Your Ref: OWPC19959
Our Ref: AW/218/18/HH
Please ask for:
Amber Willard

13th September 2018

Proposed outbuilding in rear garden
11 St Richards Way Aldwick

OUTBUILDING DRAWING
LAYOUT PLAN
11 ST RICHARDS WAY
PO21 3BD C. NEWSON

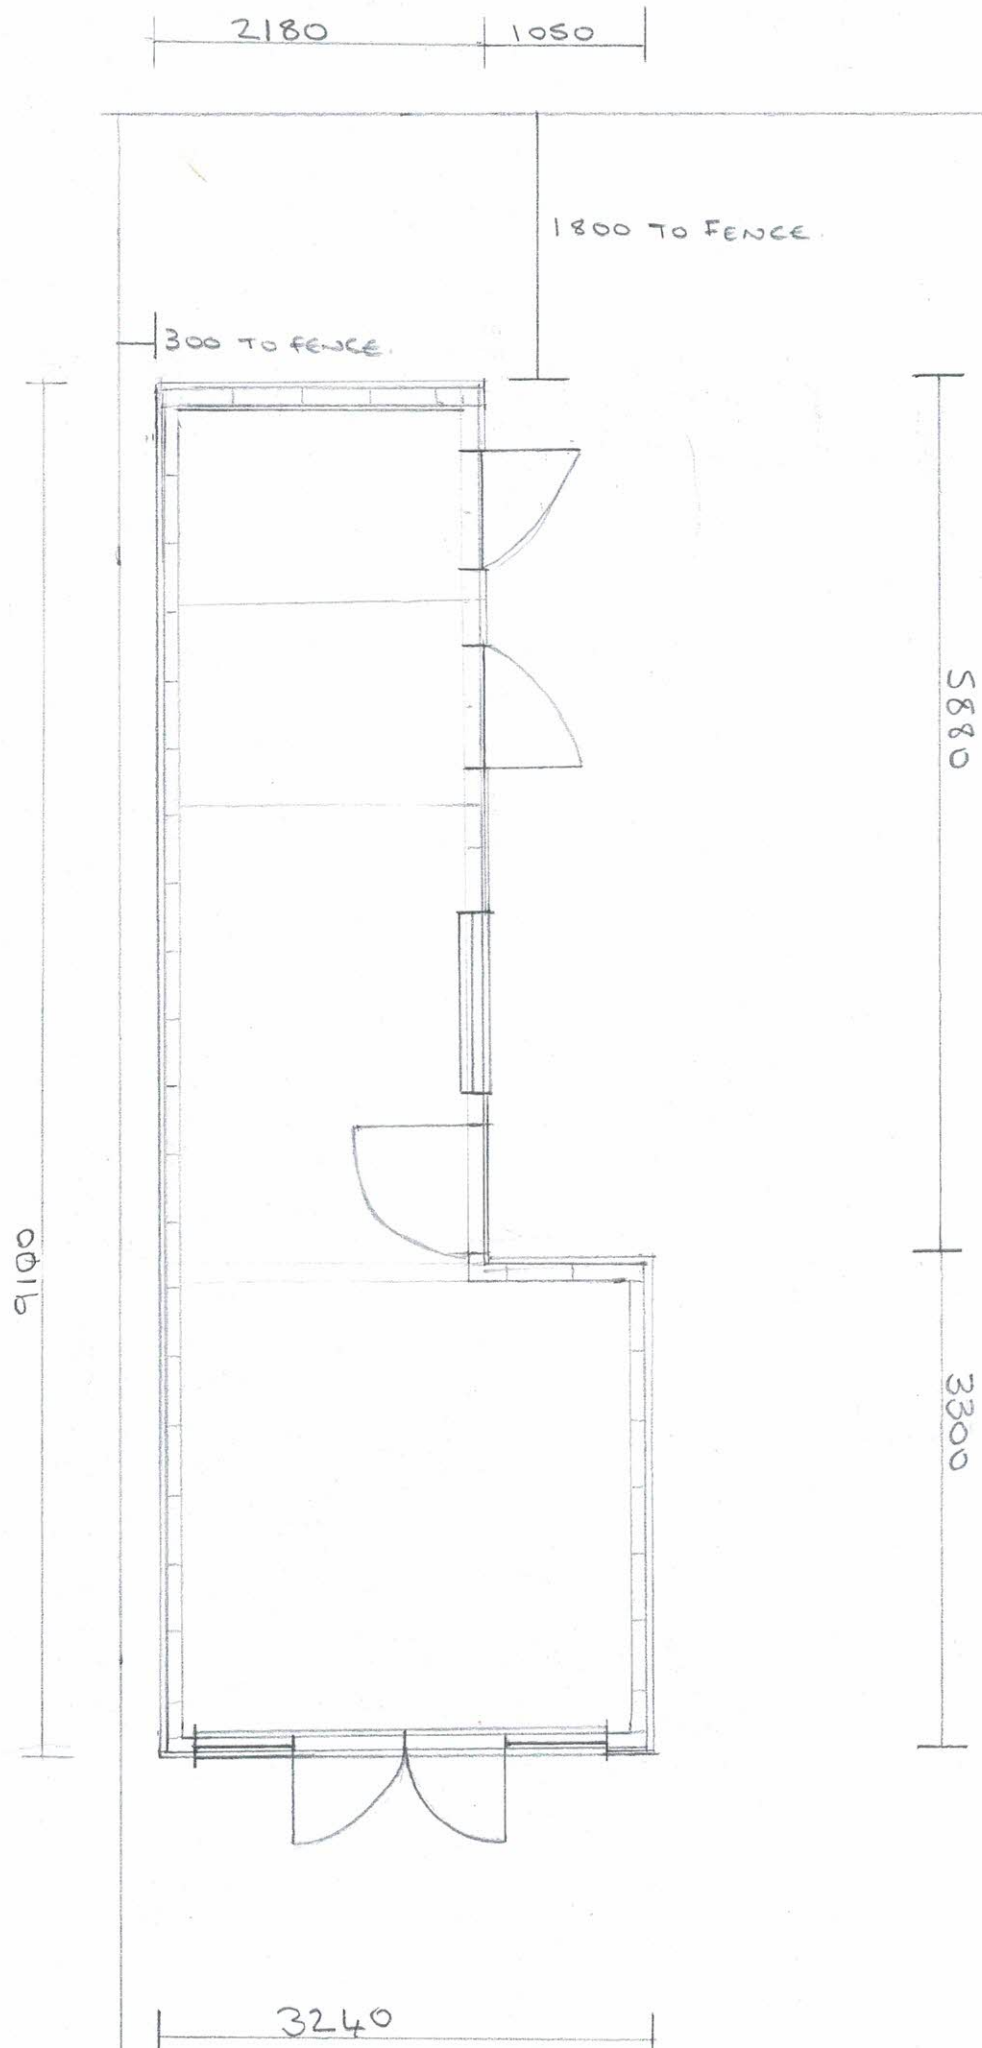
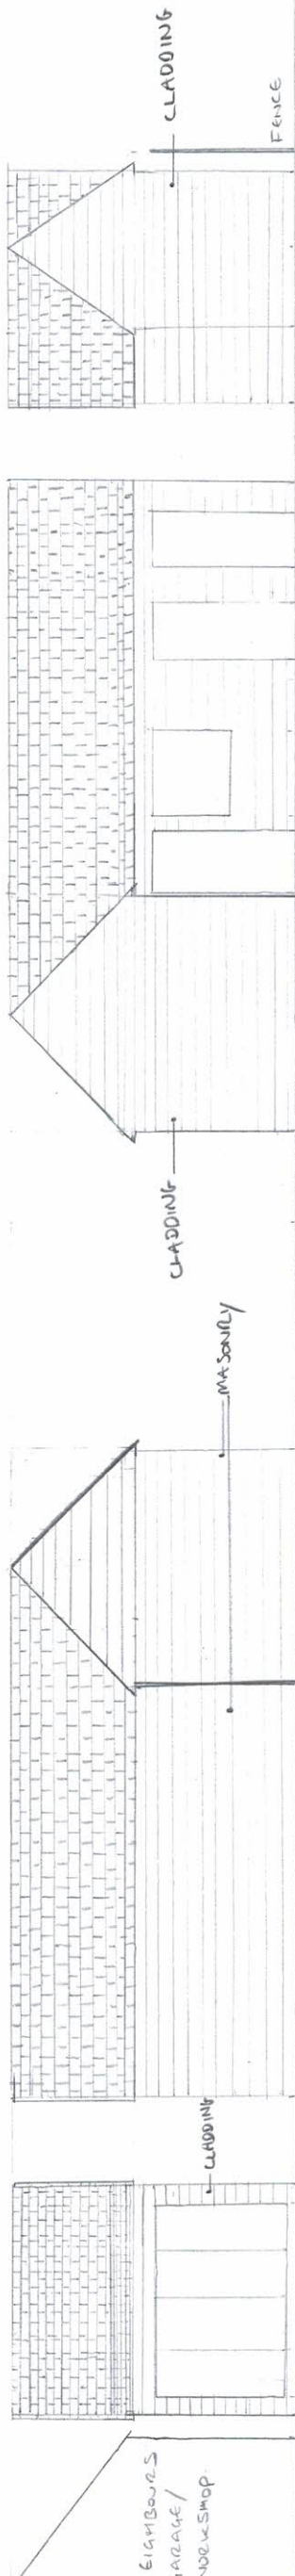
Members opposed the application on the grounds that the proposed outbuilding in the rear garden will have an adverse overshadowing, overbearing and overlooking effect on neighbouring properties. Therefore Members agreed that the application is in direct conflict with Policy D DMR 4c of the Arun District Local Plan 2011-2031.
